CITY OF ALBUQUERQUE

January 24, 2025

**RE: Menaul & Vasser
2500 Phoenix Ave. NE
Grading & Drainage Plan
Engineer's Stamp Date: 01/03/2025
Hydrology File: H16D156**

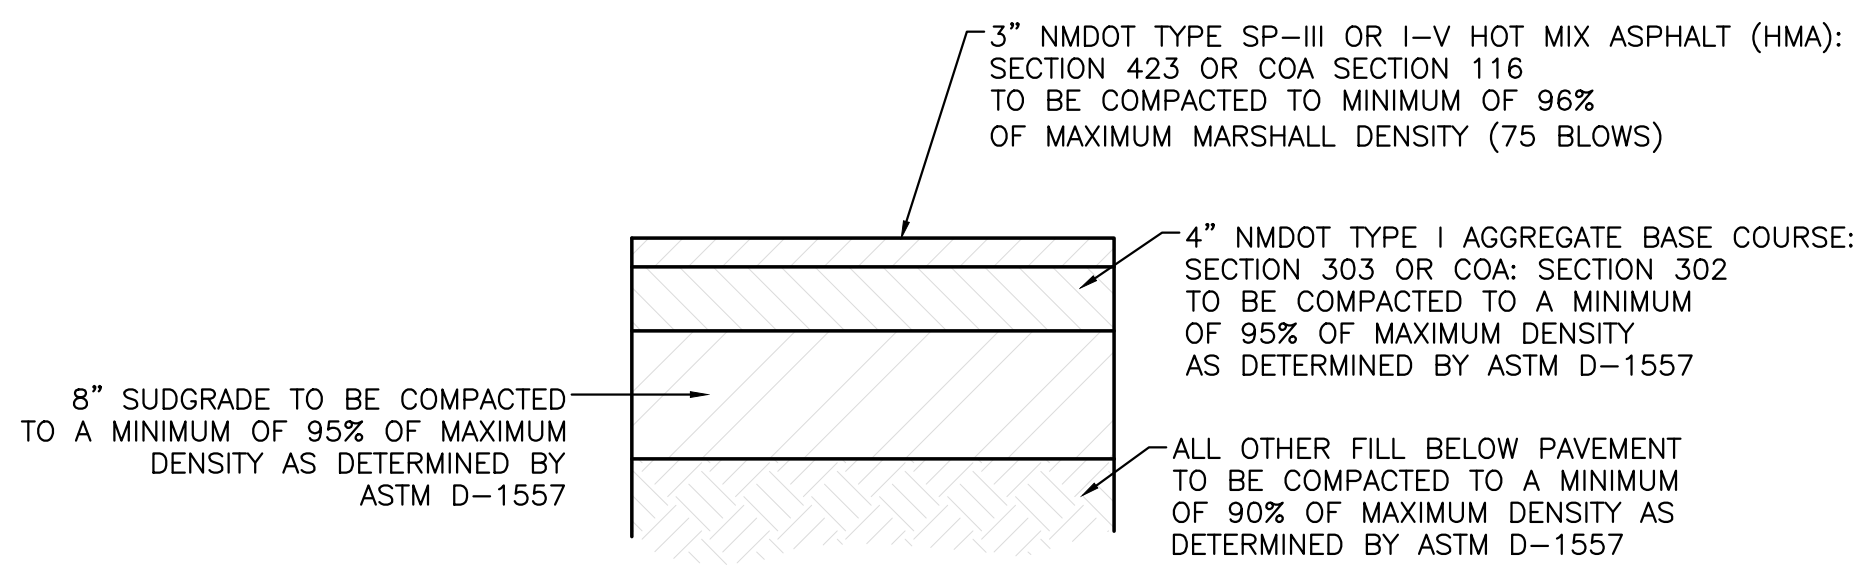
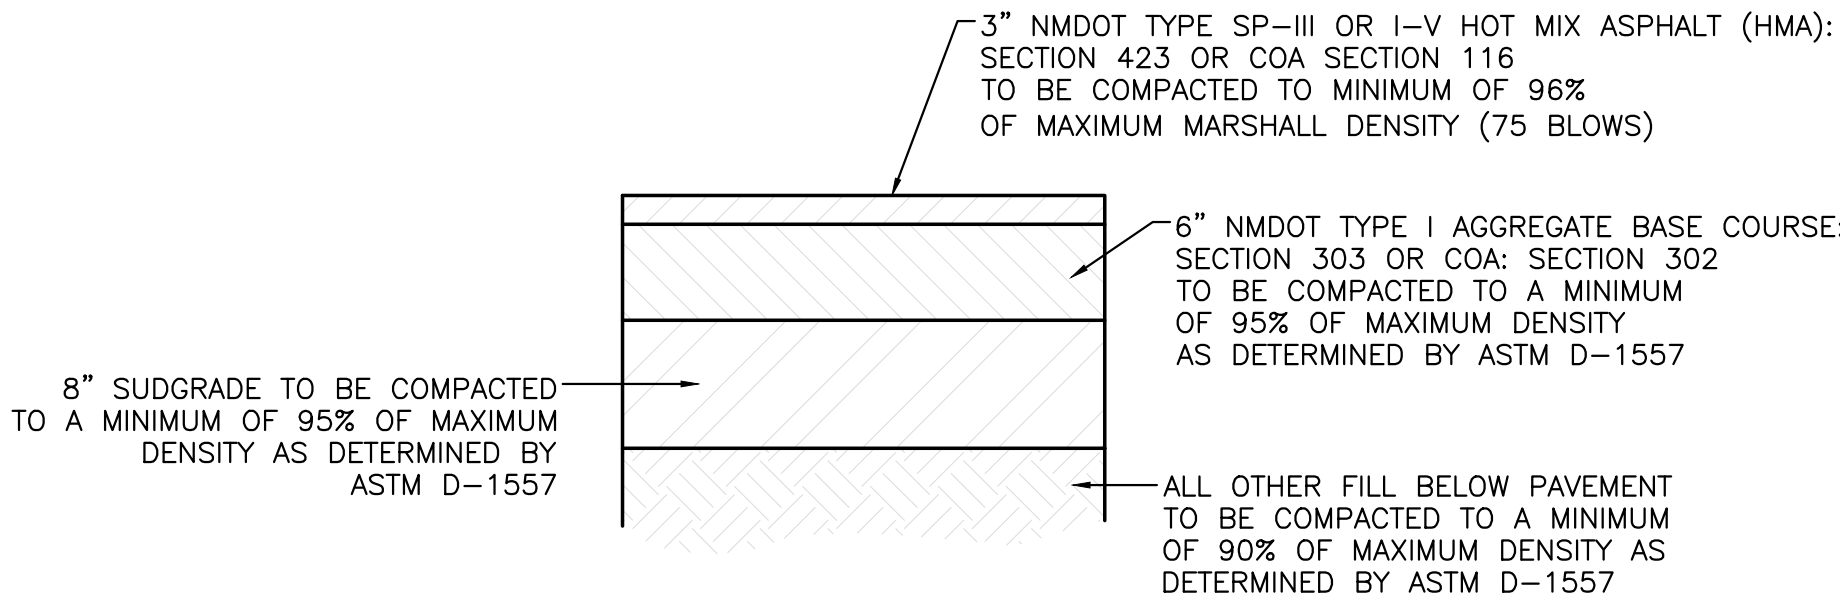
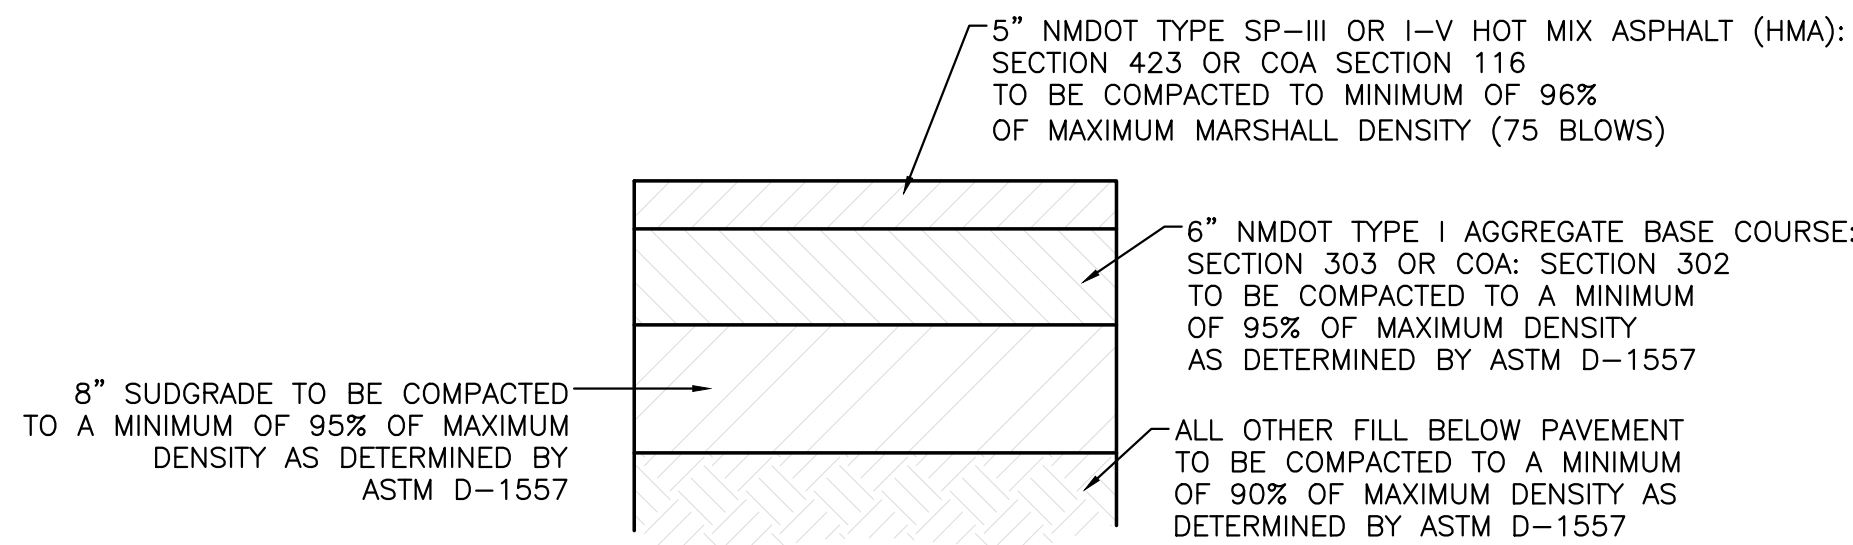
12. Sheet C5.1: A profile of the proposed base course or gravel surface should be provided together with the requirement that for stormwater conveyance purposes, the surface materials are to be compacted to a minimum of 100% maximum density as determined by ASTM D-1557.
